Case Officer: Andrew Lewis

Proposal: Discharge of condition 5 (hard surfacing) of 21/02825/F

- Drawing – HEYF-SK405 Rev A – Phase 9 Proposed Temporary Sales Area.

DRAWING NO. HEYF-SK405 REV A

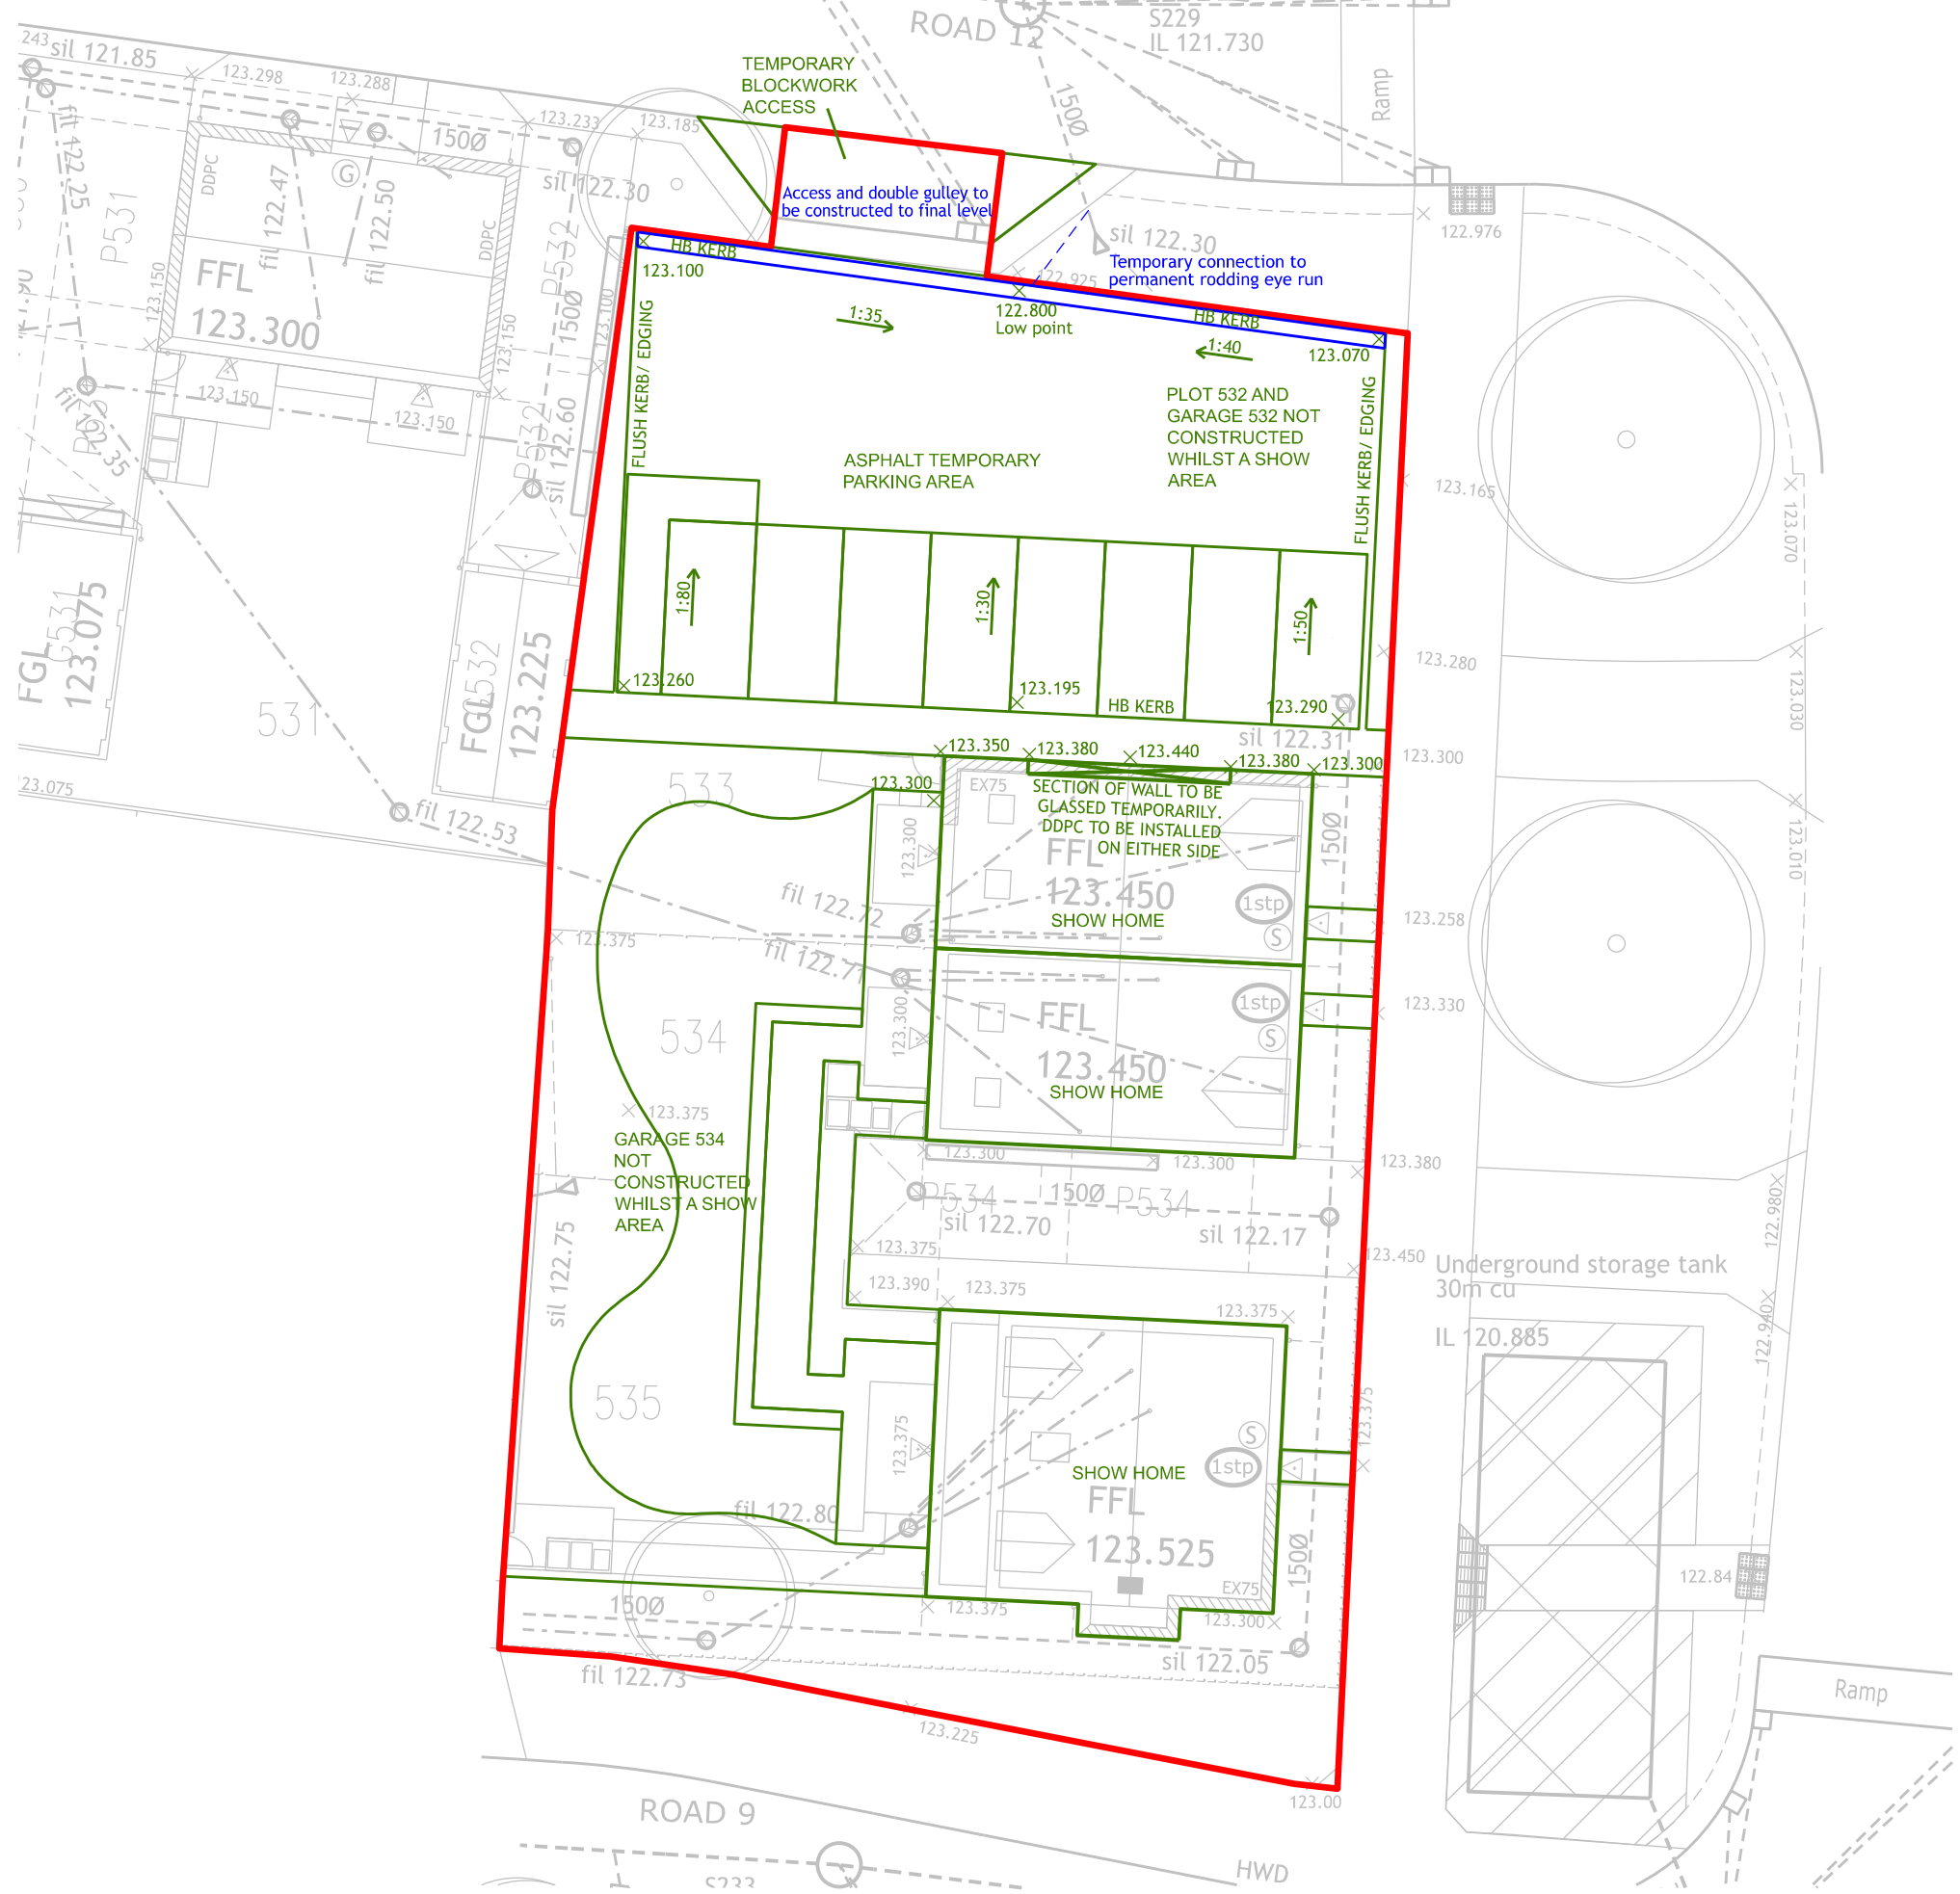
- The Sales Area car park outfall drains into the private drainage, and thence to TW S104 drainage. For information, the 'Temporary Blockwork Access' is part of the S38 adoption area – and so will need reinstating after the seven years.

They conclude there is no objection.
